From: Sue Howell <Sue.Howell@arun.gov.uk>
Sent: 22 April 2021 17:14
To: Planning.Responses <Planning.Responses@arun.gov.uk>
Cc: Anita Gardner <Anita.Gardner@arun.gov.uk>
Subject: FW: Planning Consultation on: LU/58/21/PL

Response to Planning Application

Application ref: LU/58/21/PL

Description: Erection of a semi-detached building comprising 2 No. 3 bedroom house with associated parking & landscaping. This application may affect the setting of a listed building and is in CIL Zone 2 and is CIL Liable as new dwellings.

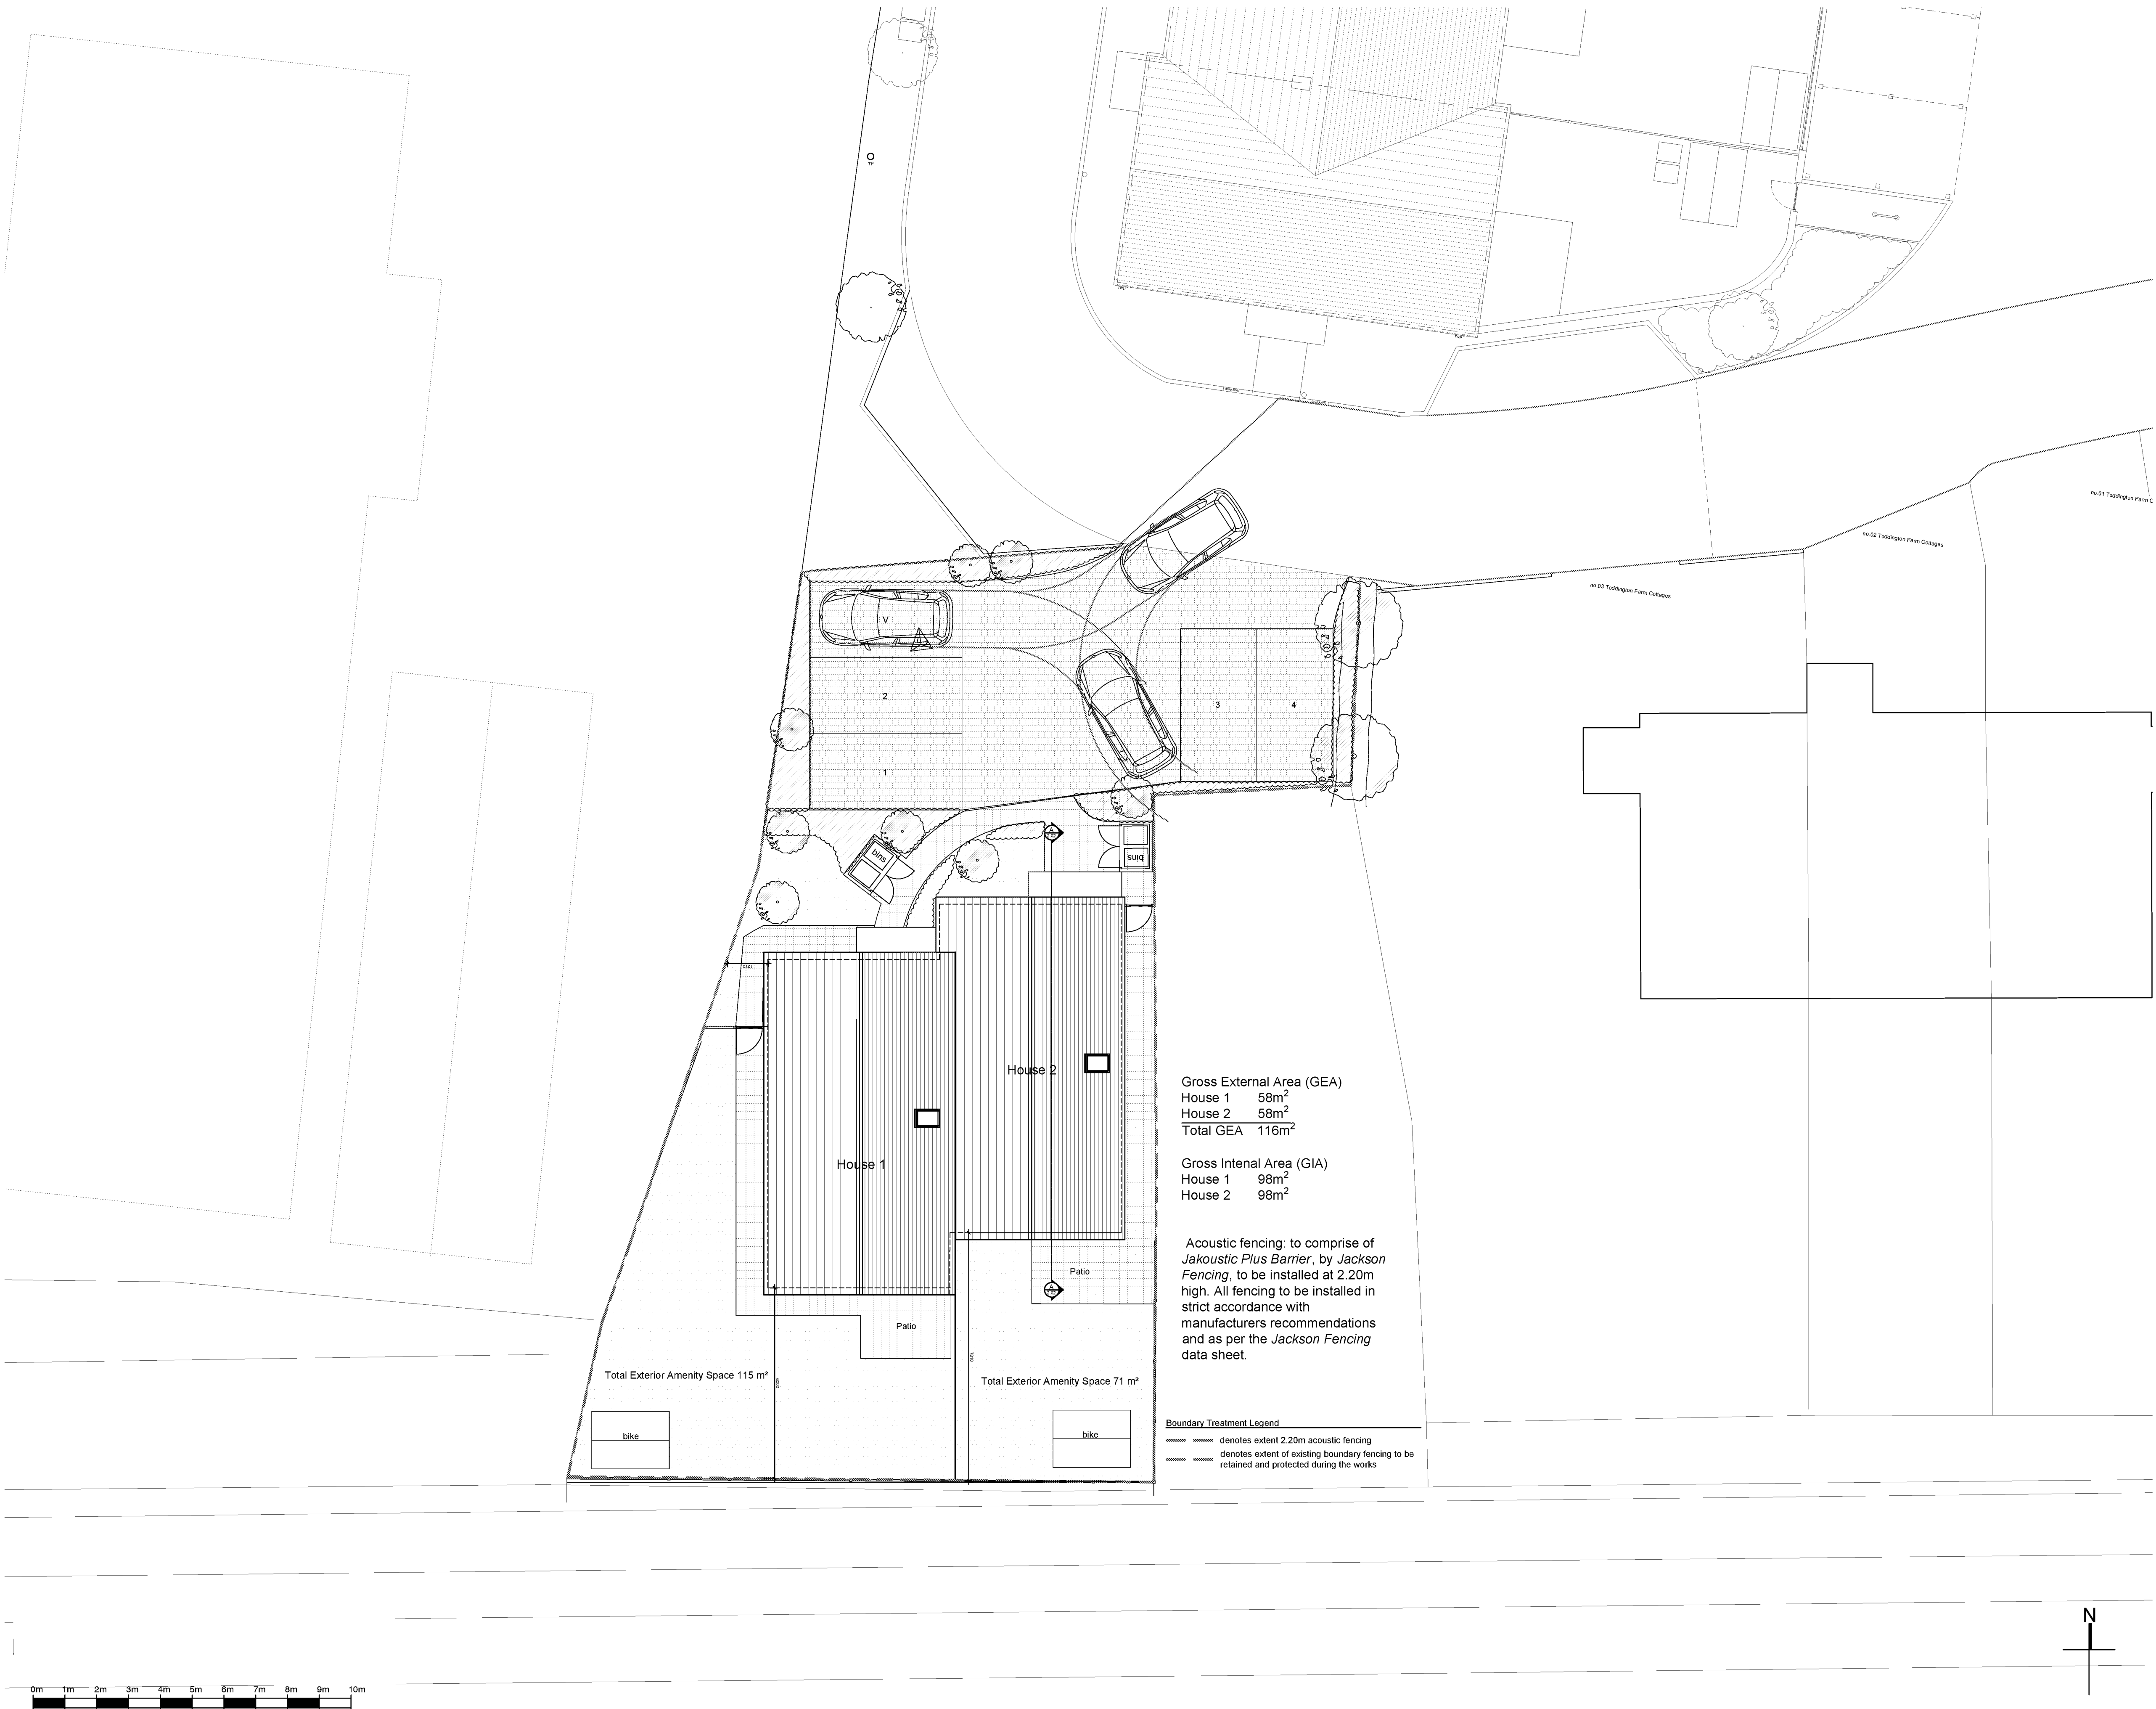
The NPPF para 124/127 relate to good design principles which equally apply to small infill and replacement development. The indicative site layouts has made reference to indicative planting along the frontages of these new dwellings. These details would require expanding in the form of a detailed planting plan and specification detailing species choice, actual plant quantities, planting densities and size at time of planting.

These dwellings would fit within the scheme of new dwellings in this location. The rear garden of these proposed dwellings adjoin a boundary with an existing railway line. Planting will need to be considered within the boundaries to screen along the boundary and the shown 2.2m acoustic fence.

Garden sizes needs to meet the requirements of Aruns Design Guide SPD Jan 2021

Landscape provision to the dwellings will need to be confirmed along with the recommendation to provide screen buffer planting to the rear gardens. All proposed planting should be considered and its connection for biodiversity and habitat explored, with a biodiversity net gain following development. Trees specified should be at a size which allow instant impact, but which will establish and mature as the site develops.
